Your Ref: OWPC2865
Our Ref: LU/118/14/PL
Please ask for:
Mr C Cronin

4th June 2014

Change of use & extension of part of former office building to a G P Practice with associated parking, landscaping & highway works.

Former Bodyshop Offices Courtwick Lane Littlehampton

Figure 3.2: Layout of Proposed Development

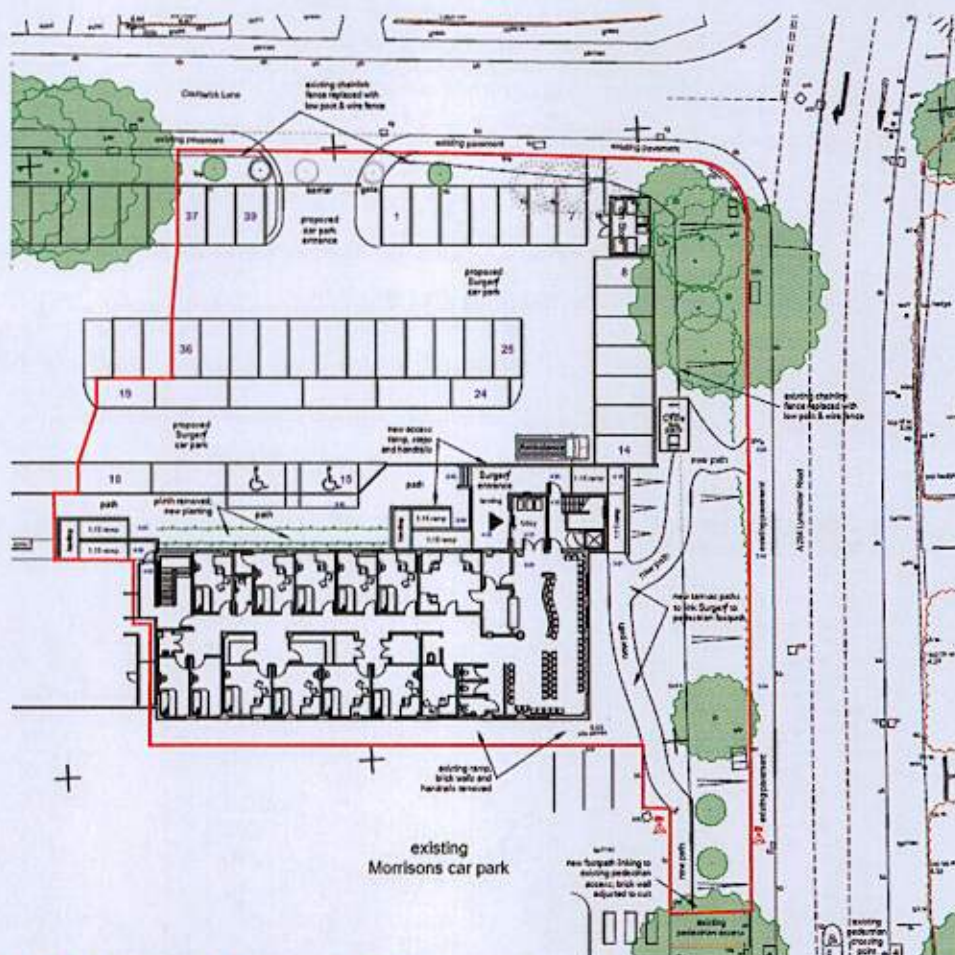
- 2. When planning permission was originally granted for the development of the enterprise hub, a new single access point from Courtwick Lane was agreed. Crucially, this was located at a position that would have reduced the impact of the traffic generated at the site on the residential housing opposite. The Town Council therefore objects to the proposed position of the second entrance which is positioned opposite residential housing and is in close proximity to the junction with the A284.*

- 3. Regarding the proposed second entrance, consideration needs to be given to the provision of the extended bus service which will serve the new housing estate at Kingley Gate. Bus stops were proposed for both the north and south side of Courtwick Lane in the vicinity of the proposed new entrance to the medical centre.*

- 4. The proportion of parking (39 spaces) allocated to the new medical centre is disproportionate to those required by the enterprise hub. If the number of parking spaces required by the Hub were calculated in the same way as the transport statement produced*

in support of the application, the Hub should have 65 spaces but is left with just 47. The Town Council therefore wishes to see the car parking allocation between the two sites more evenly allocated to reflect area of building occupied by the medical centre and the enterprise hub respectively. The Town Council would support a division of 30 spaces for the medical centre and 56 for the enterprise hub.
